**SSD 6010 - One Residential Building (Student Accommodation) within  
Darling Drive Plot**

**Submission by:**

**Mrs Anita Smythe**

**21 July 2013**

SICEEP - SSDA3 Shadow Study

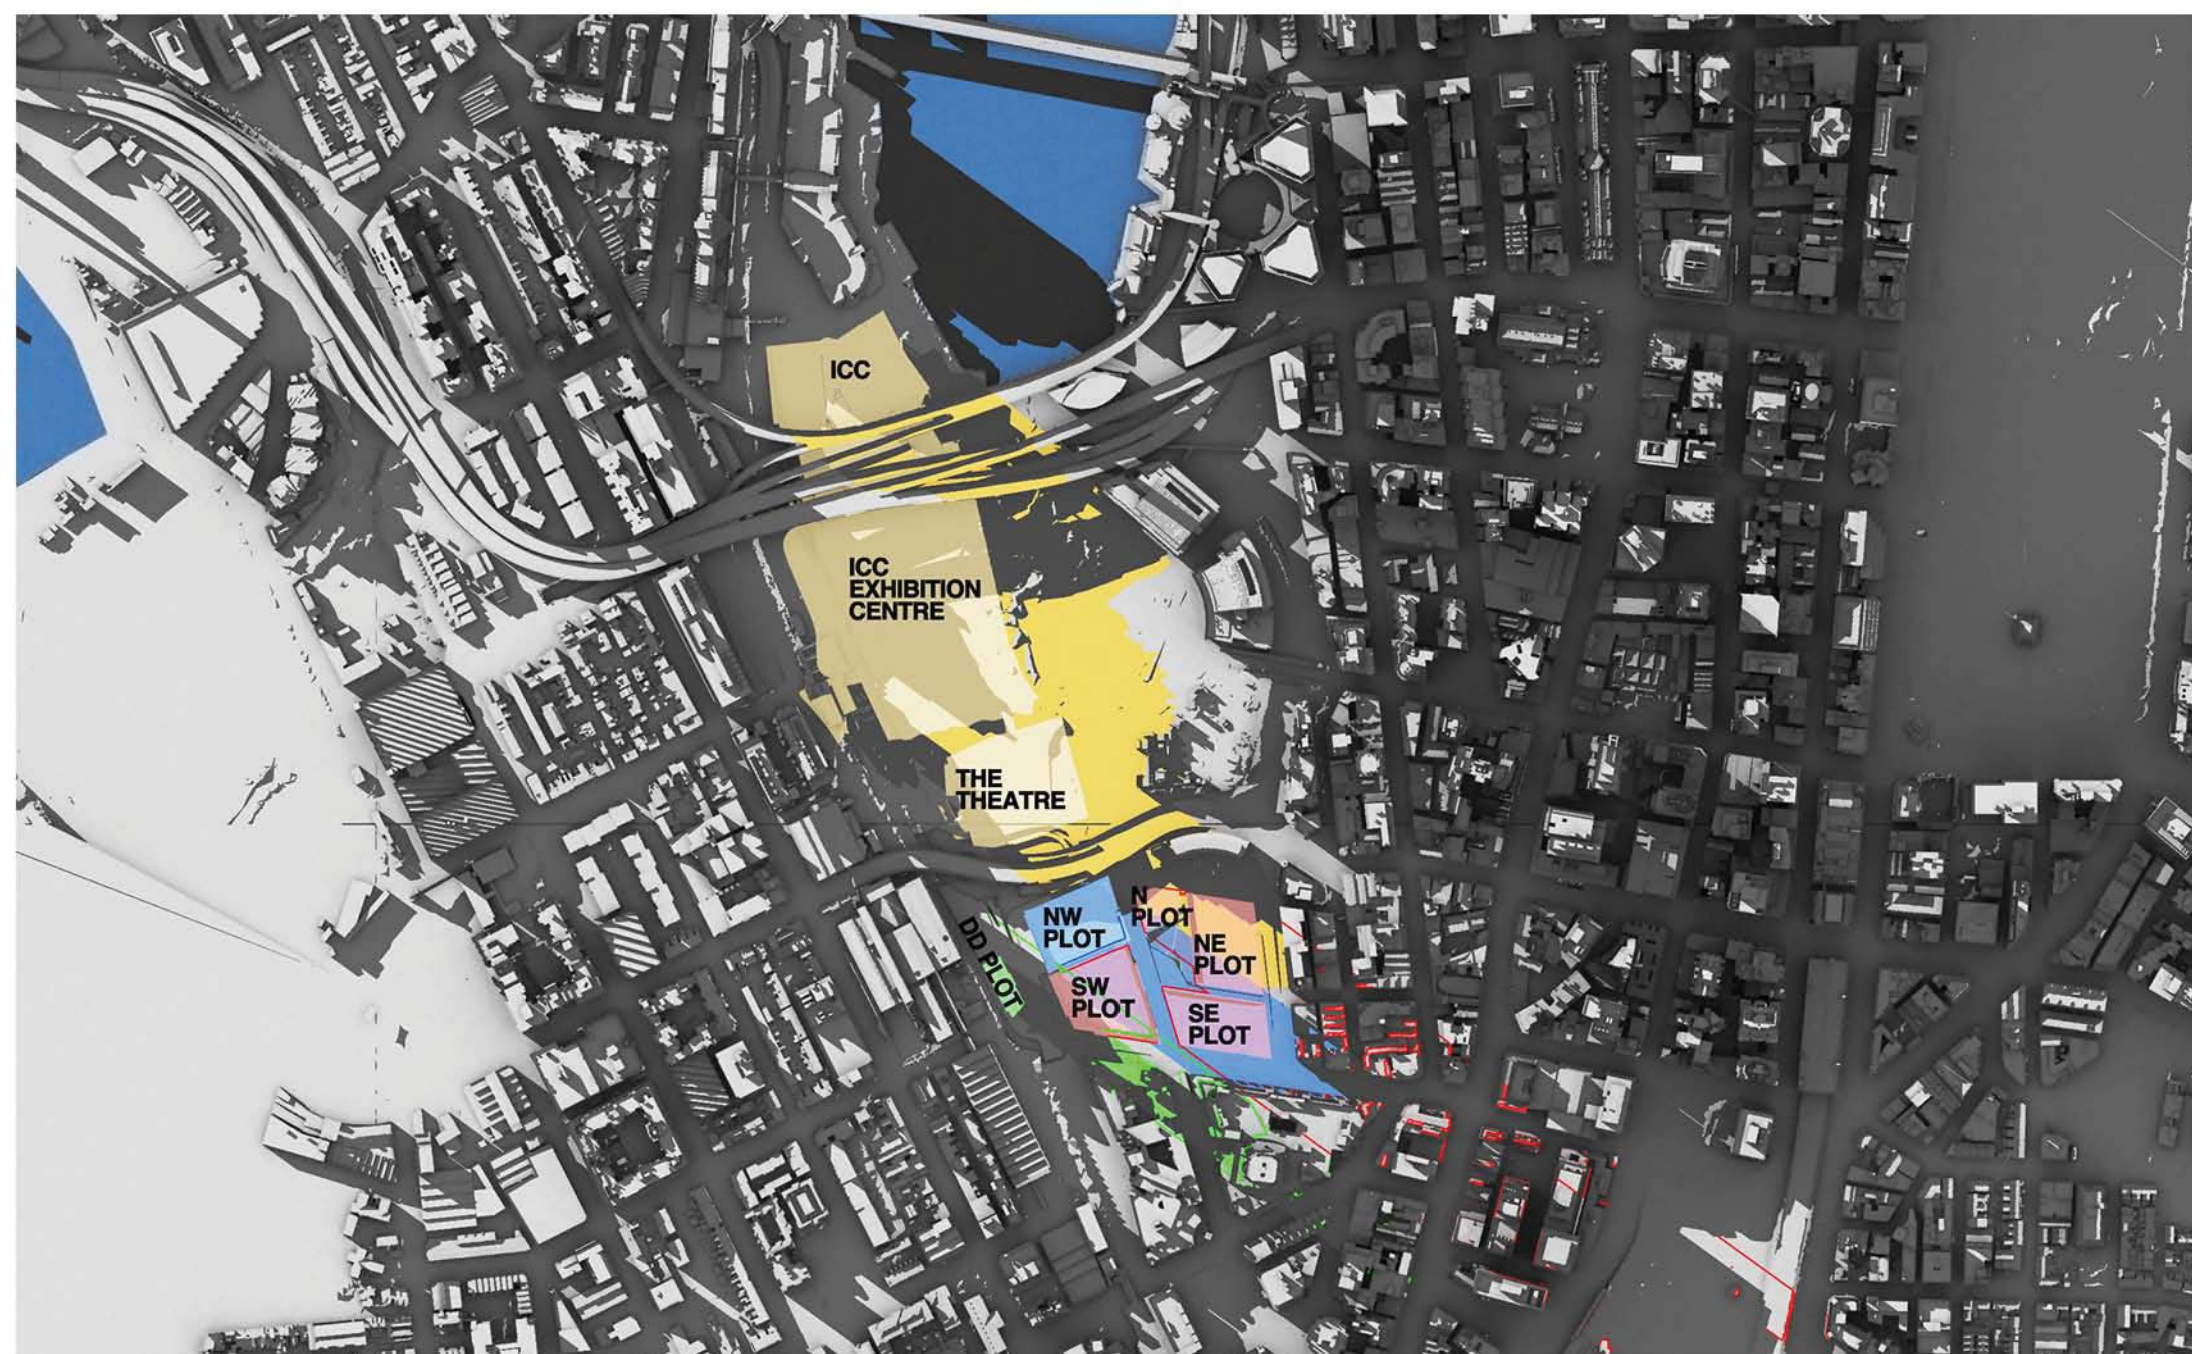
At 9am, 10am and 11am the west façade is totally in shadow due to other parts of The Peak building itself.

At 12pm there is still substantial existing shadowing on the west façade caused by the irregular shape of the west facade.

At 1pm the existing shadowing has been substantially removed, but not totally removed.

It can be concluded that some single aspect apartments on the west façade and some south-west dual aspect corner apartments currently receive less than 2 hours direct sunlight to habitable rooms and 50% of the private open space between 9am and 3pm on 21 June.

By 2pm the existing shadowing has been totally removed, but that is too late to achieve two hours of direct sunlight before 3pm.

At 9am, 10am and 11am the west façade is totally in shadow due to other parts of The Peak building itself.

At 12pm there is still substantial existing shadowing on the west façade caused by the irregular shape of the west facade.

At 1pm the existing shadowing has been substantially, although not entirely, removed. However, overshadowing of lower levels of the west façade by the concept proposal parameter plan shadows for the N,NE and SE plots has already started.

By 2pm the existing shadowing has been totally removed. However, overshadowing of the west façade by the SSDA4 and SSDA5 buildings has appeared and risen further up the west façade than the concept proposal parameter plan shadows for the N,NE and SE plots, which is still present.

At 3pm, the proponent states correctly that 45-45% of the western façade is overshadowed by the SSDA4 and SSDA5 buildings.

It can be concluded that, as a result of combination of the proposed development with existing shadowing of the west façade, some single aspect apartments on the west façade and the south-west dual aspect corner apartments which currently receive less than 2 hours direct sunlight to habitable rooms and 50% of the private open space between 9am and 3pm on 21 June will suffer additional overshadowing. It is beyond our skills to count the number of such apartments. We note that the proponent has made no attempt to do so.

Rather than counting the number of units which will not meet the DCP guidelines, the proponent attempts to trade-off direct sunlight at 4pm for lack of direct sunlight during the period 9am to 3pm. There is no provision in the DCP guidelines for such a trade-off.

SHADOW DIAGRAMS: PERSPECTIVE, SHOWING THE PEAK, WINTER SOLSTICE

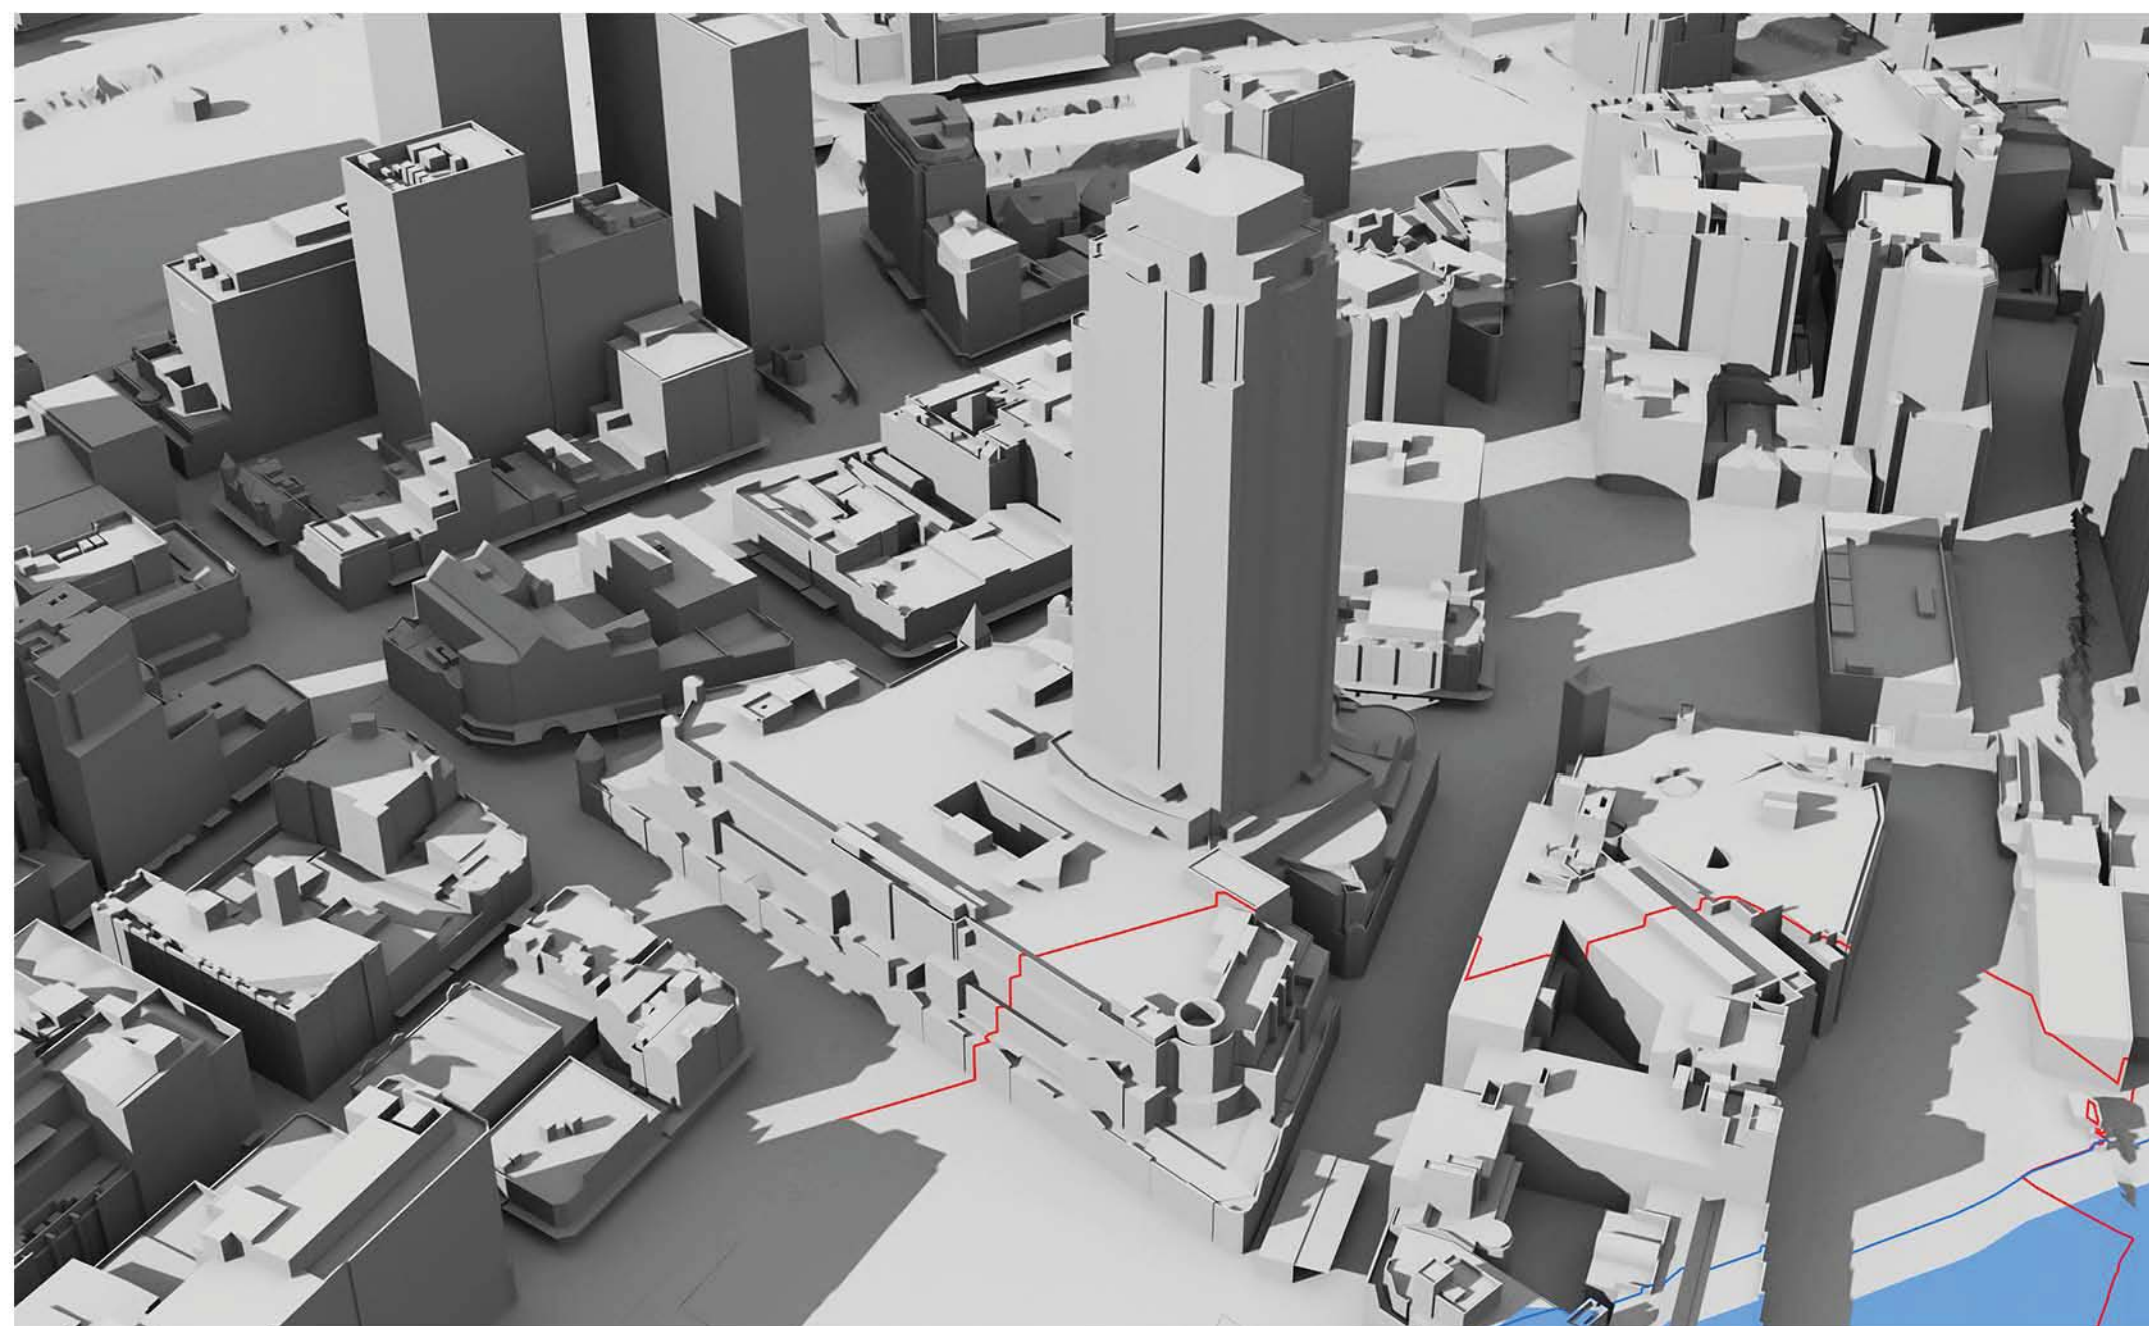
The proponent (and apparently also the consent authority) still does not accept, much less take into account, the fundamental fact that many apartments within The Peak are indeed single aspect.

The proponent fails to take into account the existing shadowing of the west façade of The Peak.

The proponent appears unaware that the DCP guidelines refer to sunlight between 9am and 3pm; and not to periods before 9am or after 3pm.
